Our Reference: SYD12/01218
Your Reference: MP11_0046
Contact: Pahee Sellathurai
Telephone: 8849 2219

STAGE 3 RESIDENTIAL DEVELOPMENT AT 61 MOBBS LANE, EPPING

Reference is made to your correspondence dated 9 October 2012 with regard to the abovementioned development application, which was referred to the Roads and Maritime services (RMS) for comments.

PARKING - ARCH

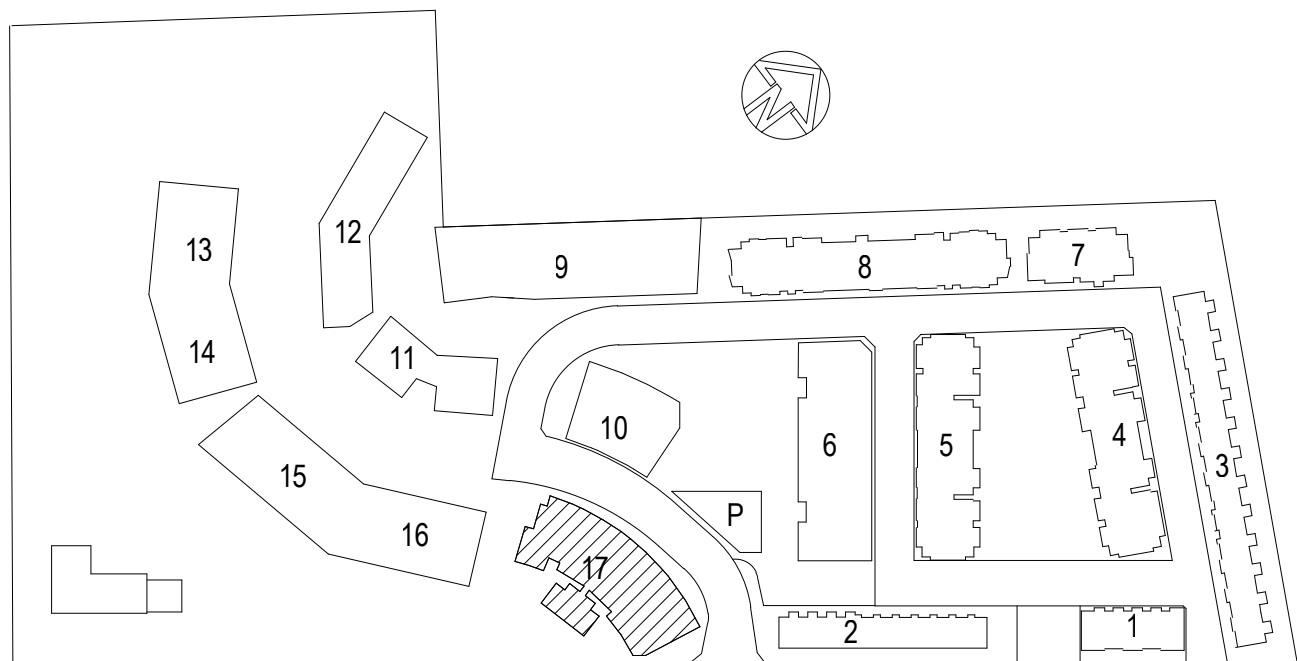
2. The DP&I should ensure that the layout of the proposed car parking areas associated with the subject development (including, driveways, grades, turn paths, sight distance requirements, aisle widths, aisle lengths, and parking bay dimensions) are in accordance with AS 2890.1 - 2004 and AS 2890 - 2002 for heavy vehicles.

3. The circulation ramps should be in accordance with AS 2890.1 – 2004 and to DP&I's satisfaction.
4. The turning paths for waste collection vehicles entering the bin collection area have not been shown on the submitted plans. The access roads should be wide enough to ensure that they will accommodate the turning paths of the proposed maximum sized vehicle that will utilise the access when entering and exiting the subject site.

5. The internal aisle ways are to be marked with pavement arrows to direct traffic movements in/ out of the site and guide traffic circulation through the car park.

6. The minimum available headroom clearance is to be signposted at all entrances and clearance is to be a minimum of 2.2 metres (for cars and light vans, including all travel paths to and from parking spaces for people with disabilities) measured to the lowest projection of the roof (fire sprinkler, lighting, sign and ventilation), according to AS 2890.1 - 2004.

8. Turning areas should be provided at dead-end isles within basement car parks. These turning areas within the car park are to be kept clear of any obstacles, including parked cars, at all times.
